Engineers Comments Regarding Surface Water Drainage

Application Reference:	BN/76/26/DOC	Reviewer Reference:	ADC/EXT2/113
Planning Officer:	Amber Willard	Date of Review:	07/09/2026
Site Name:	Land South Of Wandleys Lane Eastergate PO20 3SE		
Application Description:	Approval of details reserved by condition under BN/46/25/PL relating to conditions 4- Surface Water Drainage and 9- Maintenance & Management of Sustainable Drainage Scheme.		
Assessment Number:	2

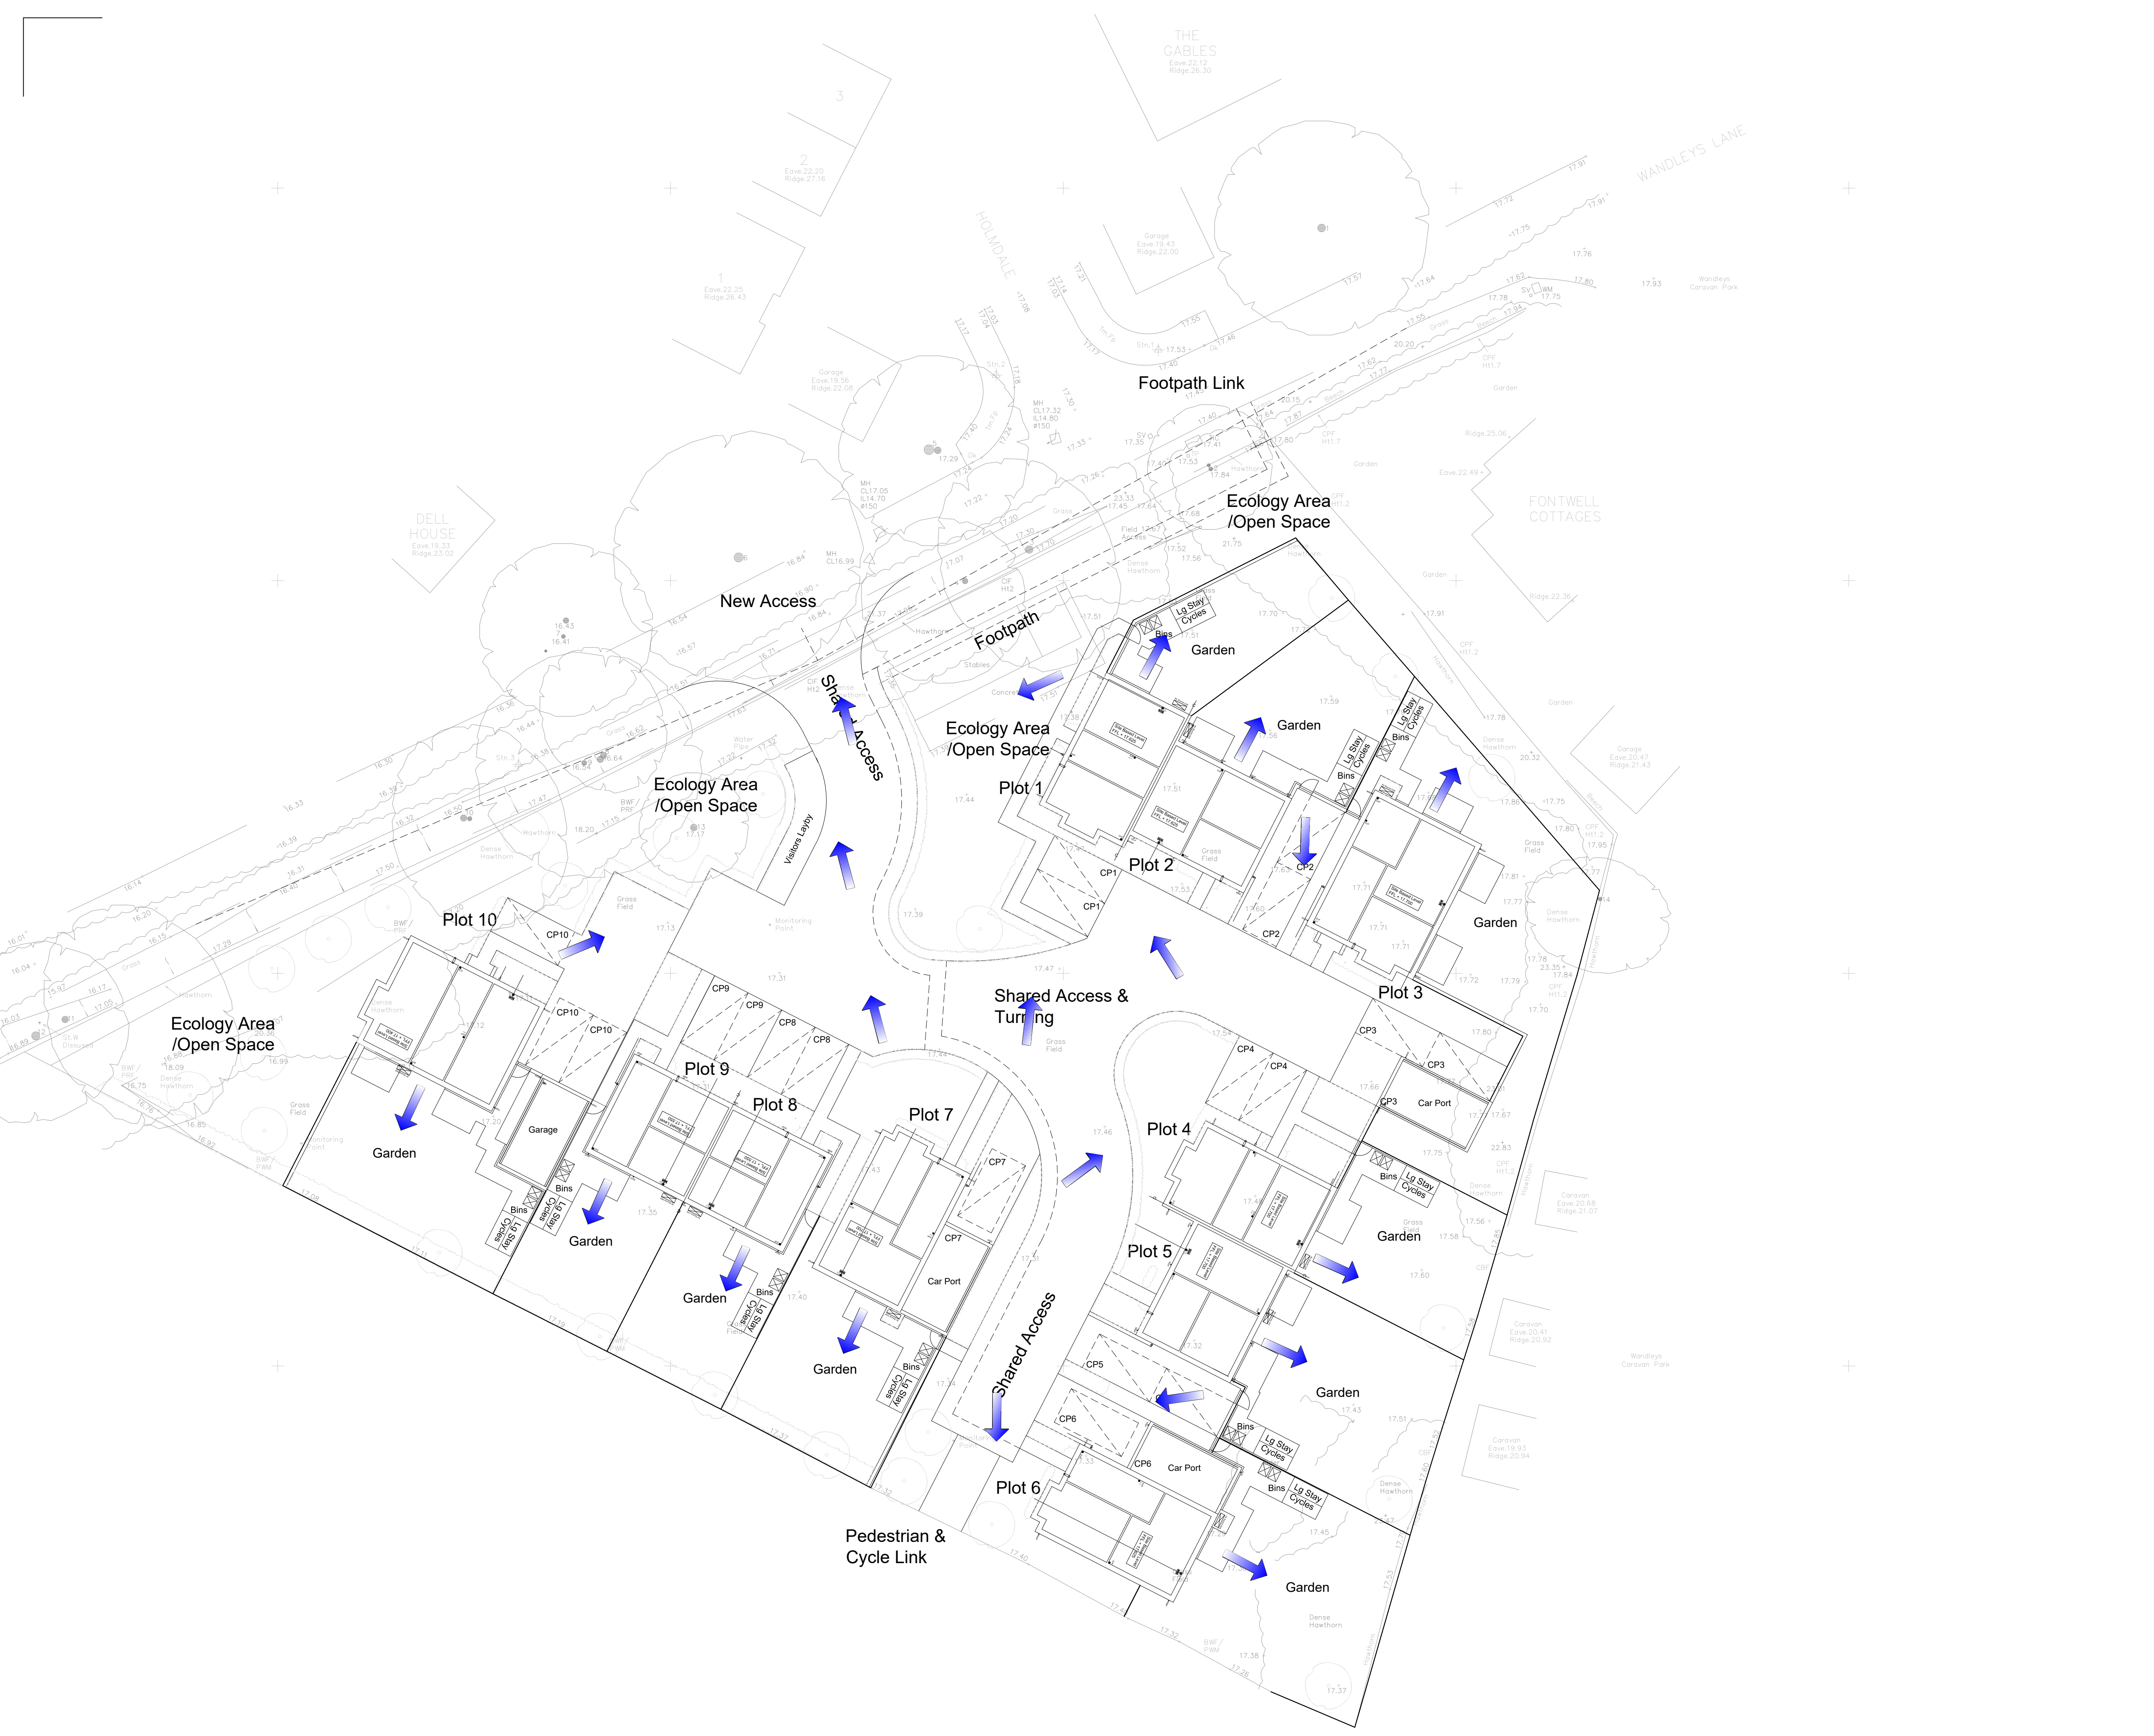
Comment Number				
1.	OK			
2.	OK			
3.	Please refer To Exceedance Plan drg. No. 476988-503_P01- Exceedance Flood Routes. Please refer to descriptor file: FEH_Point_Descriptors_494812_ 106233_v5_1_0FEH File sent via email on 10.06.26	Noted. Comment closed.		
4.	OK			
5.	The provision of water butts to each plot and utilising permeable paving within the development provides amenity benefits.	Noted. Comment closed.

Comment closed.			
8.	Please refer To Exeedance Plan drg. No. 476988-503_P01- Exceedance Flood Routes.	Noted. Comment closed.			
9.	OK
